291 Summit Street - Permit #00731

I just did an initial zoning review on the application you submitted to install a modular home at 291 Summit Street. I have a few questions/requests:

Atlantic Resource Consultants  
 541 US Route One  
 Freeport, ME 04032  
 Tel: 207.869.9050  
 DRAWN: MPV DATE: MARCH 31, 2017  
 DESIGNED: JAV SCALE: 1"= 20'  
 CHECKED: MPV JOB NO: 17-008  
 FILE NAME:  
 SHEET: C-101

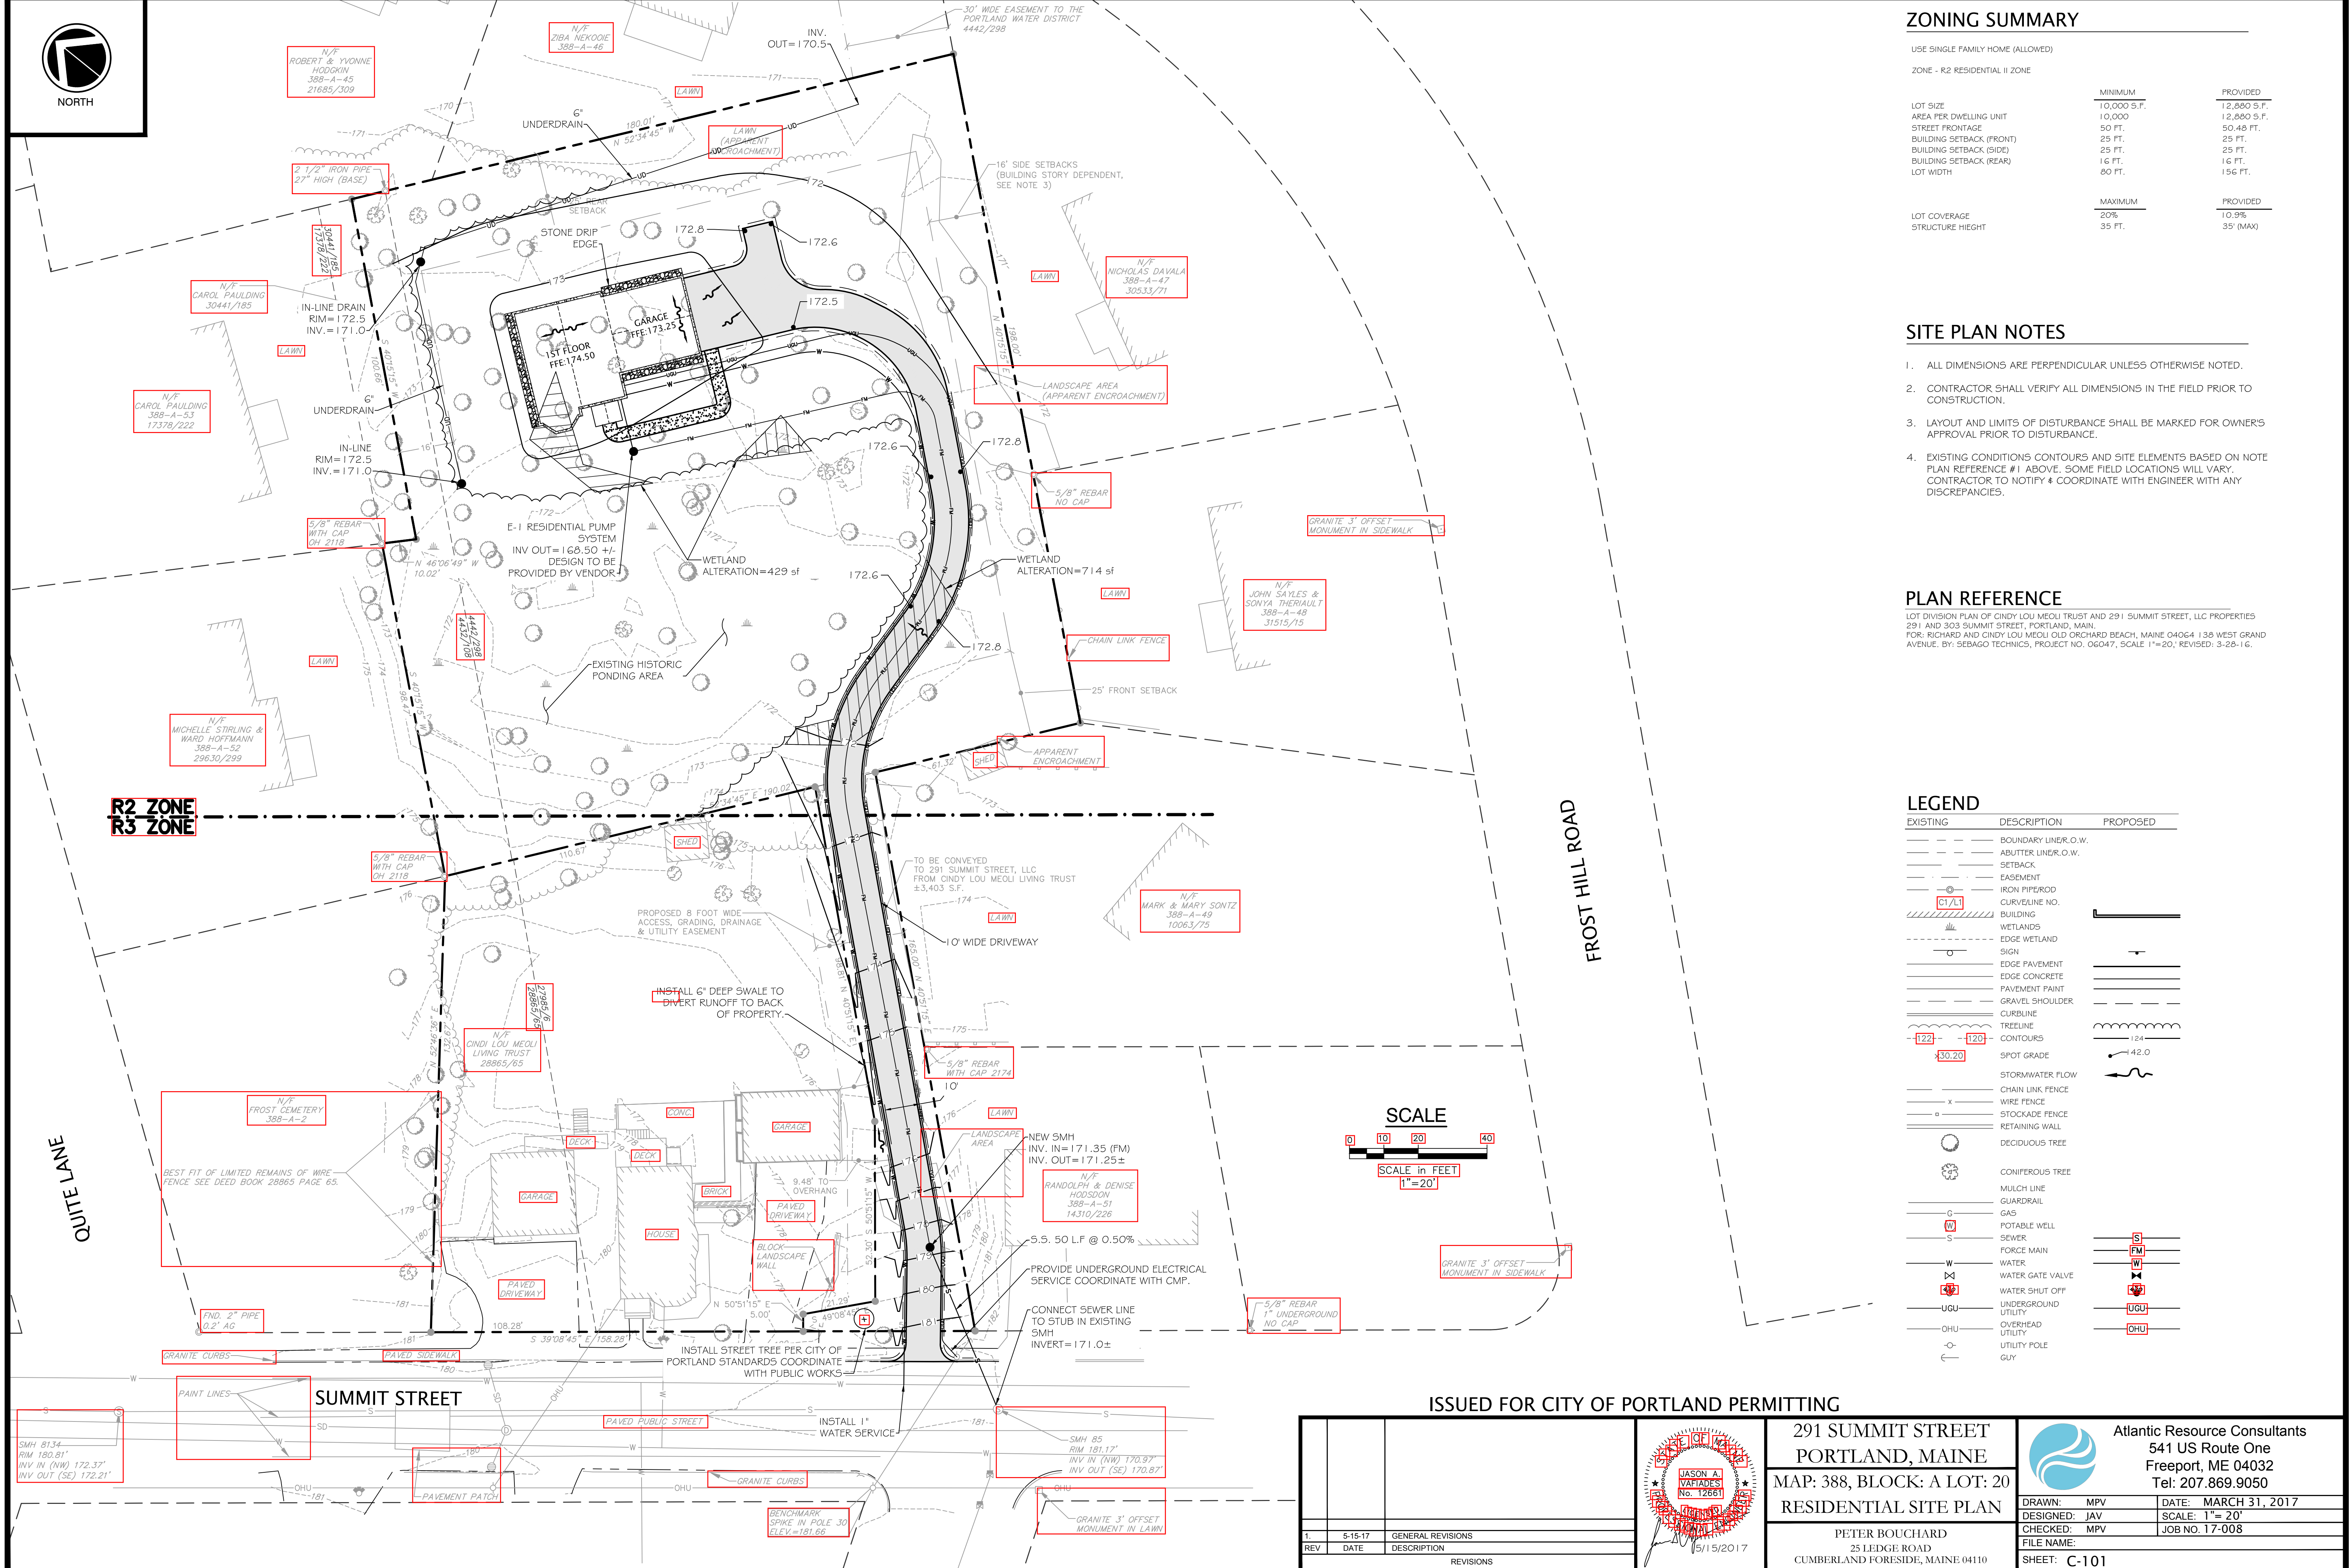
On the bearings I know that surveyors often go in different directions but in my experience the the bearing numbers are usually the same, just the directions change (so SW changes to NE, etc.). It seems like the description in the deed might use a whole different bearing system or something. I'm sure a surveyor could explain it – as I said, I just don't know enough about surveying to be able to interpret this!

2) The Residential Site Plan Sheets C-101, C-300, and C-301 seem to have some kind of mark-up on them (red boxes). See attached for example. Can the consultant provide clean copies? They can be e-mailed directly to me.

4) I might be misunderstanding (my surveying knowledge is limited), but it appears that the bearings described on the deed that was submitted do not match those shown on the site plan. Can you and/or a surveyor look at this and let me know if it is a discrepancy or provide an explanation?

Attached is the plan without comments.

I am also attaching another plan for the same property prepared by Matthew Ek of Sebago Technics. That plan shows the same bearings as the plan you already have on file. The bearing dimensions on the plans do not match the previous description in the deed due to the difference between Magnetic North used in the deed and the Grid North used on the plans. The bearings on the plans match the bearings shown on the attached legal descriptions of the subject property and the driveway and are on the Maine State Plane Coordinate System as required by the City of Portland when performing site plans. Here is a good article on this subject, <https://www.ordnancesurvey.co.uk/resources/maps-and-geographic-resources/finding-north.html>
